February 21, 2023

Salah Nouaim
11380 US 401 N
Fuquay Varina, NC 27526
RE: Dabbing Chicken

Harnett County Government Complex
307 W. Cornelius Harnett Boulevard
Lillington, NC 27546

A plan review was received by this office concerning the construction of the above referenced facility. The plans are not approved and the application is being returned at this time with the following comments:

Dabbling chicken
Floor plan

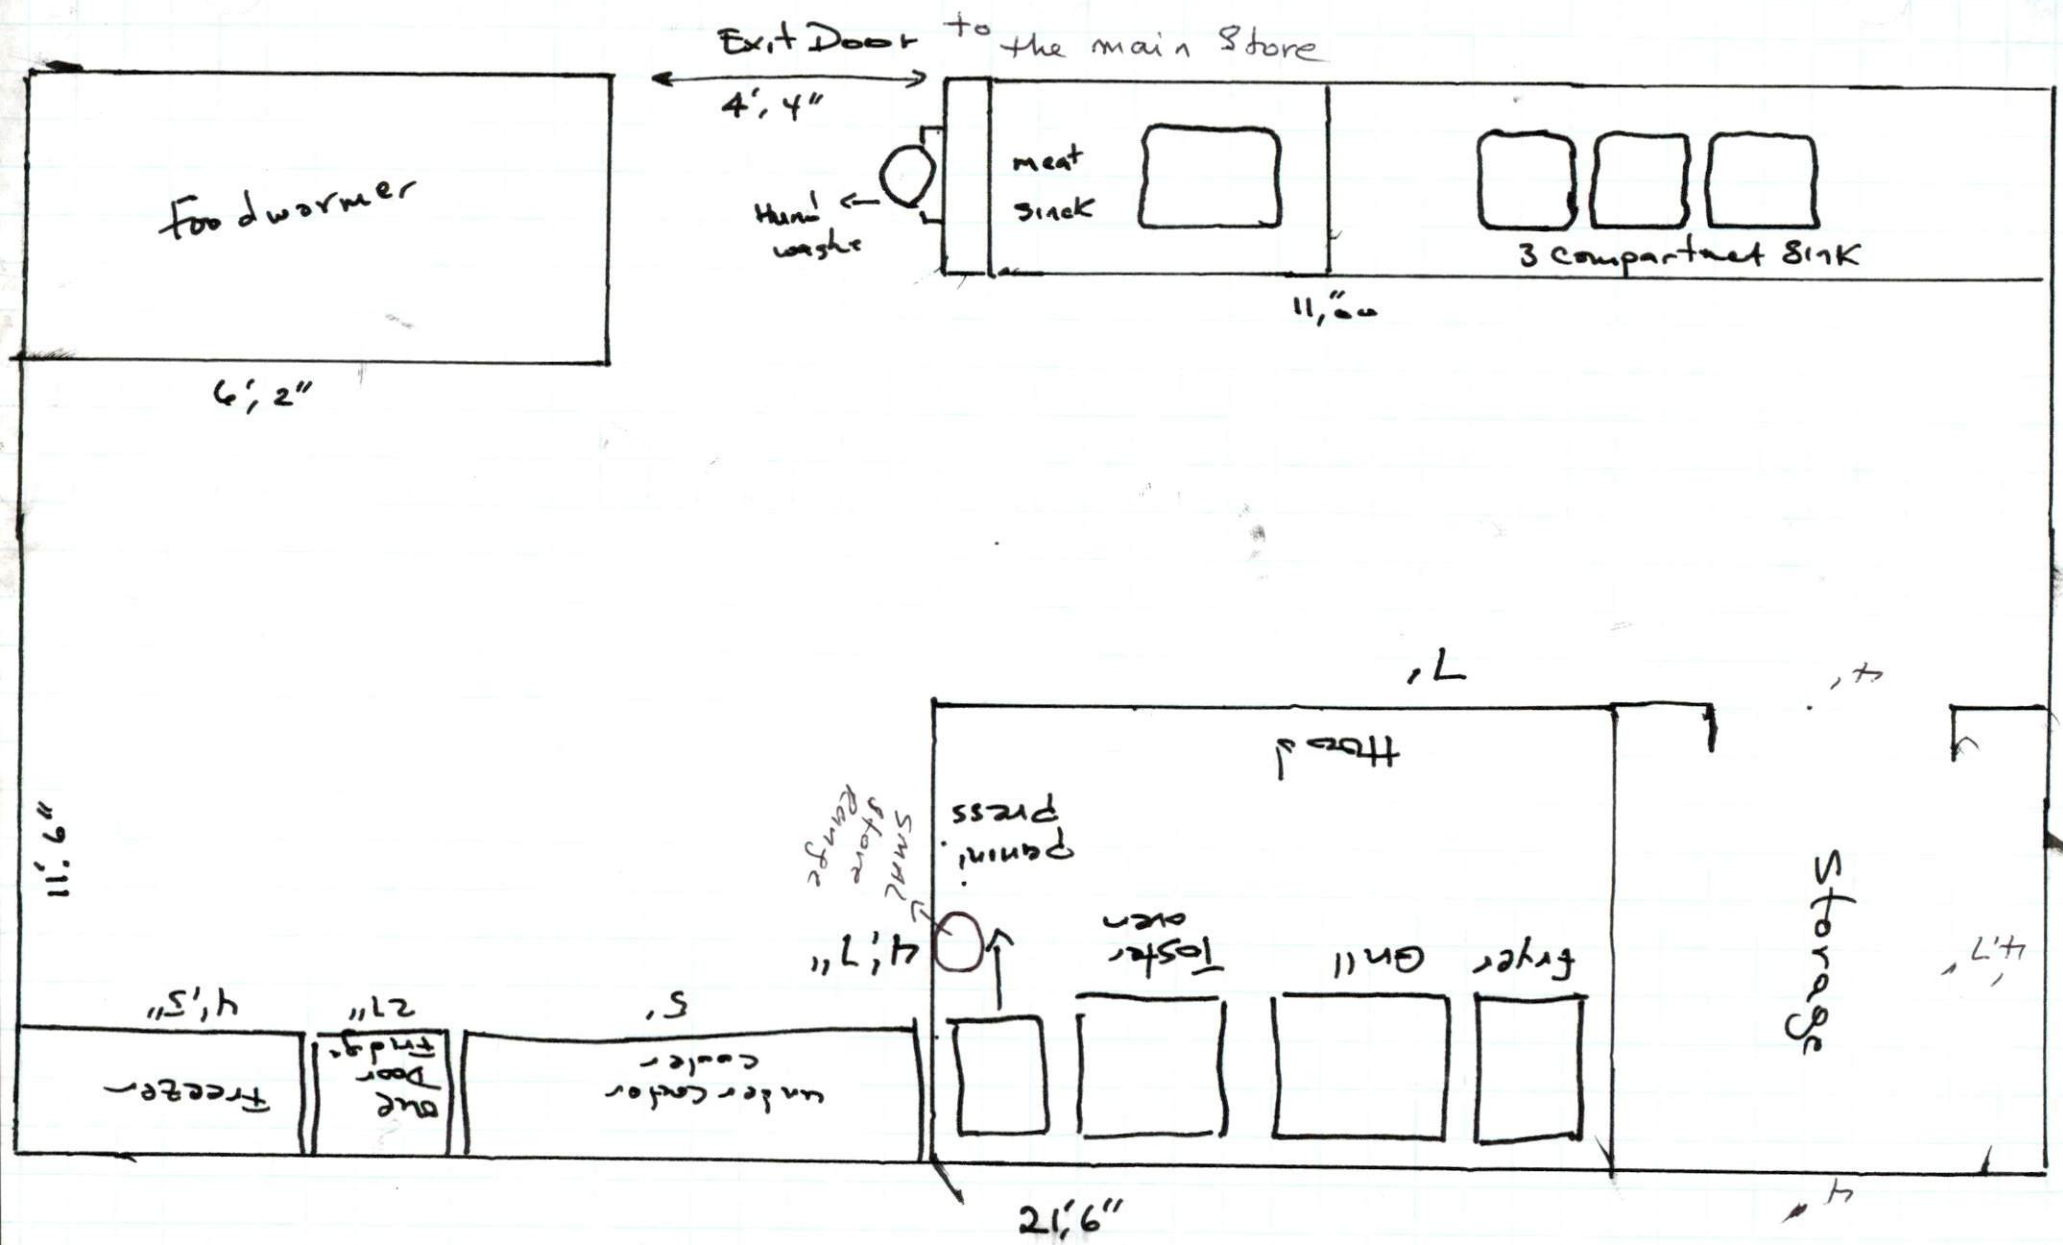
- The application has zero marked for number of prep sinks however there is a prep sink on the layout. The size of drain board in inches on the application is 1.5. Please provide truthful information regarding the number and size of prep sinks.

- The application has 2 compartments indicated for manual ware washing. The layout indicates there is a three compartment sink. The length of drain boards in inches as indicated on the application is 1.5. Please provide truthful information regarding the ware washing sink.

- No location or size of can wash facility was provided.
- Application indicates fried chicken and soups will be held hot however these items are not listed on the menu. Please provide a full menu.

Panini Press

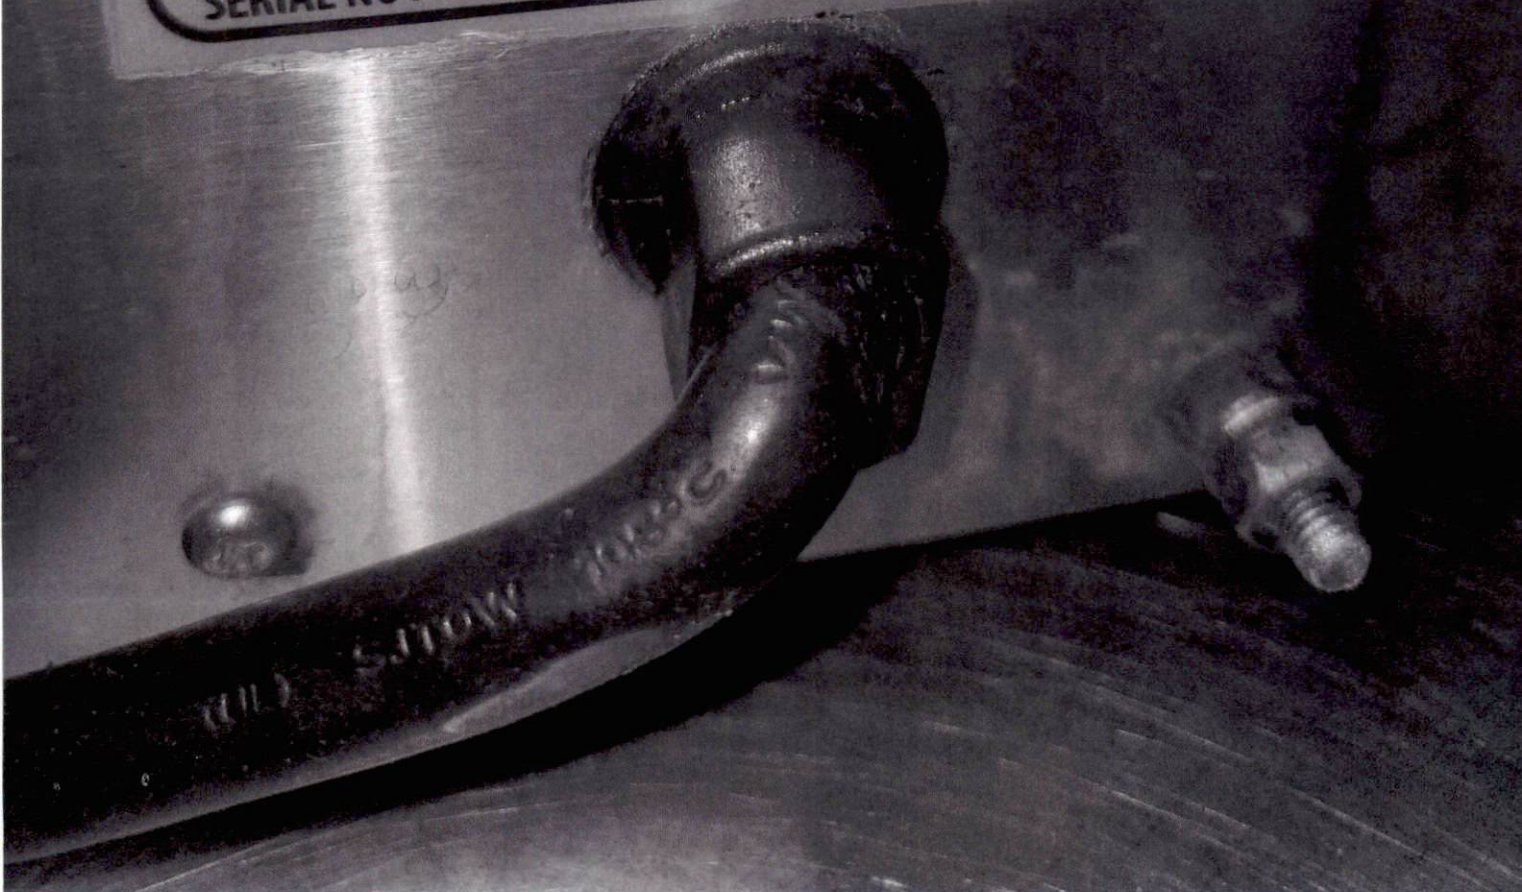
- Specification sheets are missing for small stove range, panini press, and toaster oven.
